**Consultation Response from KC,
Trees**

2025/91588 55, Bradford Road, Cleckheaton, BD19 3LB

Erection of side extension to form additional accommodation to existing house in multiple occupation

Responding Ref: SP2/70/g25

Appendix 5
Constraints Map

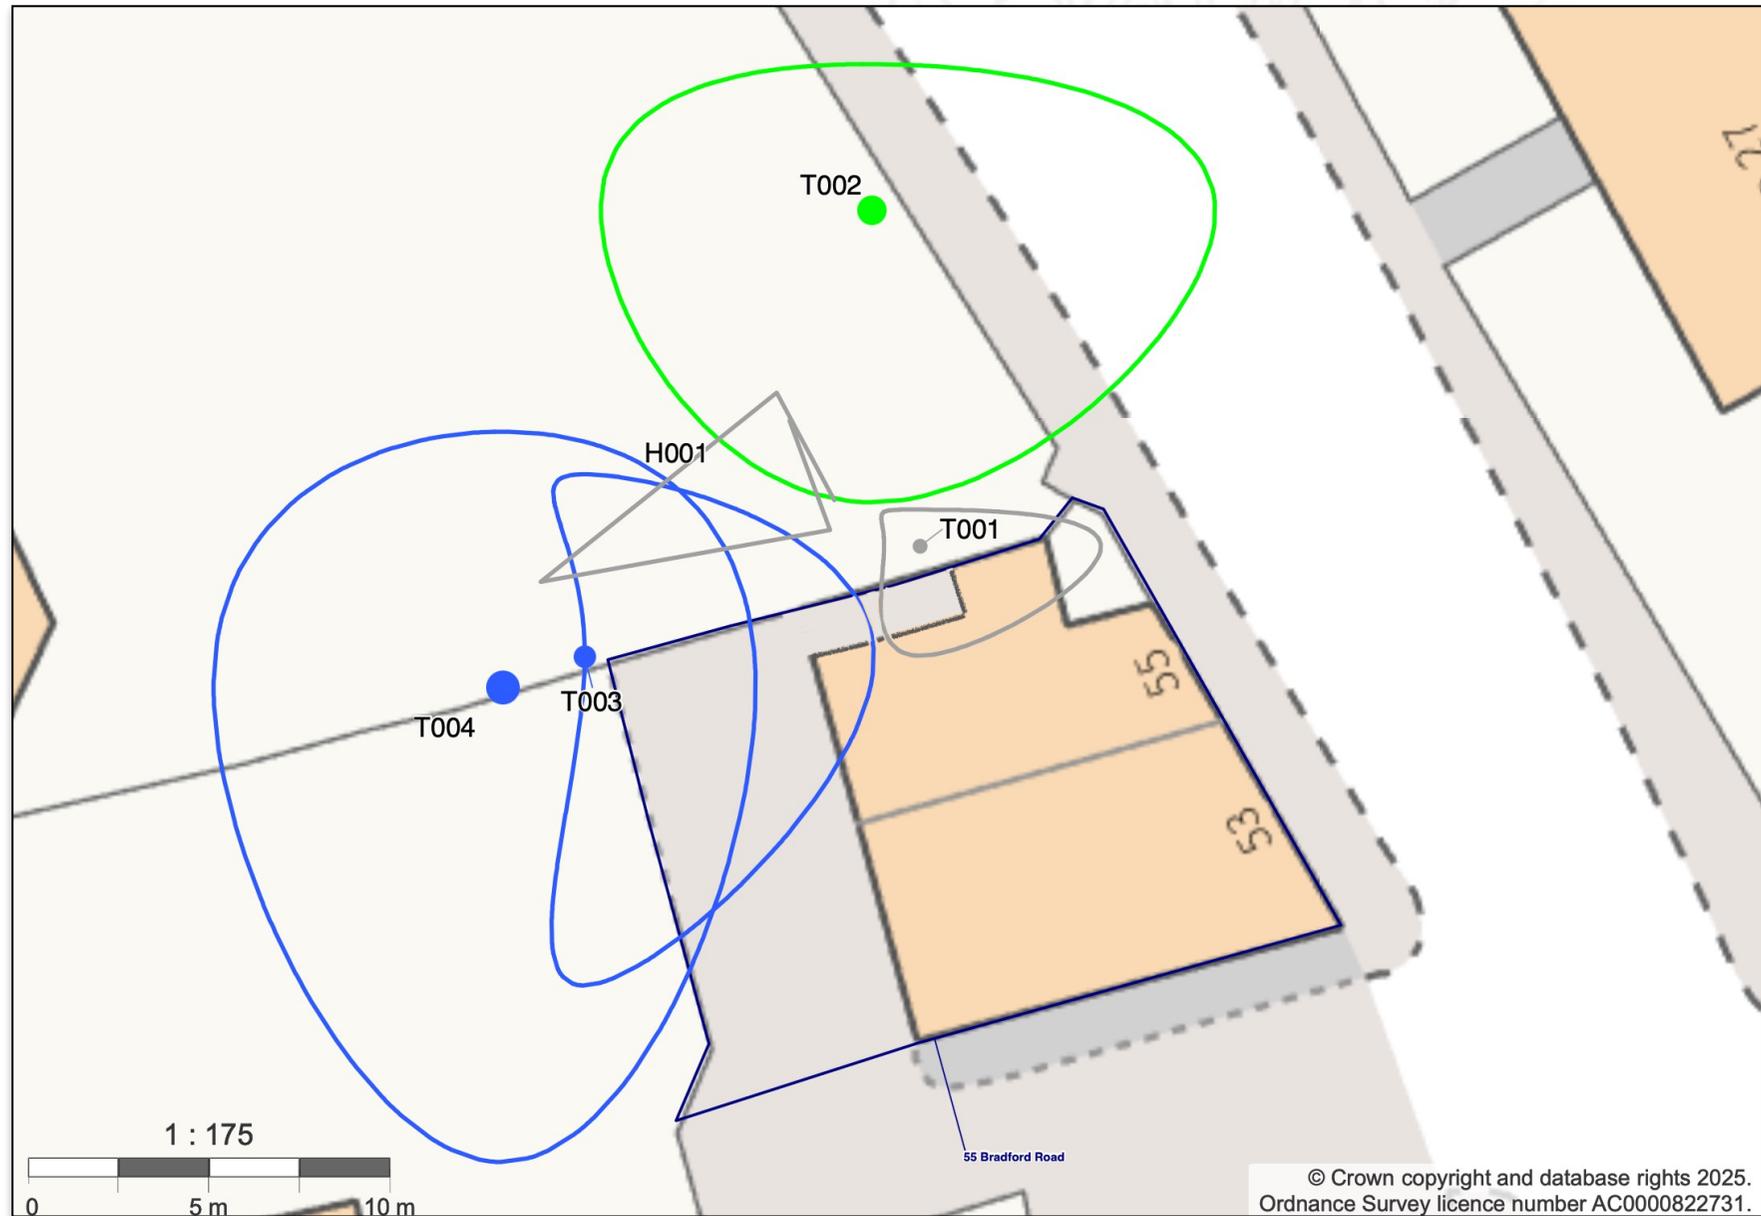
There are significant off-site tree constraints shown on the tree constraints plan. The extension is proposed both within the RPA and canopy line of valuable off-site trees. It is likely that the proposals would lead to the death of off-site sycamore T001 and also damage the rooting area of off-site trees T003 and T004, potentially affecting the long-term health and safety of these trees. This is an important consideration as they would be overhanging both the proposed and existing structures. The construction of the proposed will inevitably lead to increased future pressure on the trees for pruning or felling (with the associated financial cost).

There is an objection from an arboricultural perspective. The proposal conflicts with adopted Kirklees local plan policy 33 and 24 (i).
